Consultation Response from KC, Conservation & Design**2023/91021 23B, Bradford Road, Dewsbury, WF13 2DU****Discharge of conditions 3 (Schedule of Works), 4 (masonry repair and cleaning) and 12 (rooflights) of previous Listed Building Consent 2019/91120 for conversion and alterations to existing building to create 27 apartments****Date Responded: 22.8.2023****Responding Officer: Sue Brooks****Responding Ref: DM 2/154 and DM 2/155**

DRAWING REF: REV:
22270-D04-A

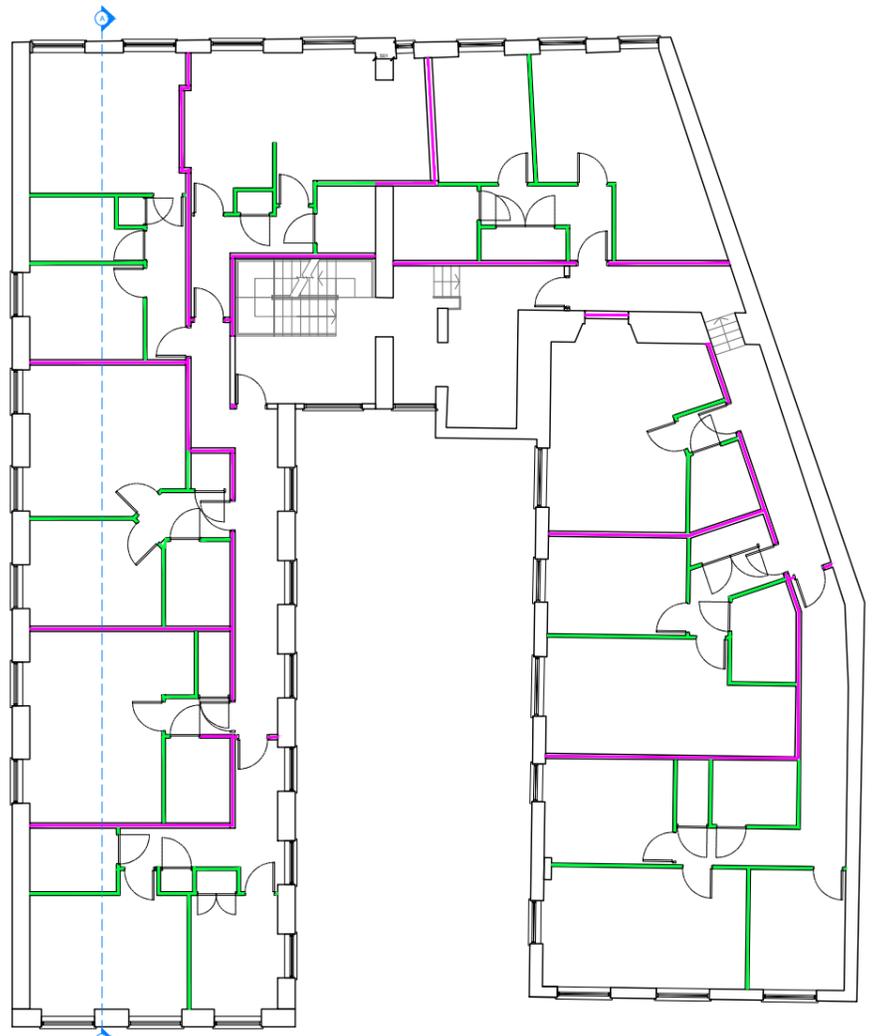
This information is **insufficient** to discharge this condition. The amount of information submitted is limited, and there are discrepancies with the approved application and the conditions associated with application 2019/91120. We would recommend that the applicant re-visits the schedule of works and provides information that corresponds with the approved application documents and relevant conditions.
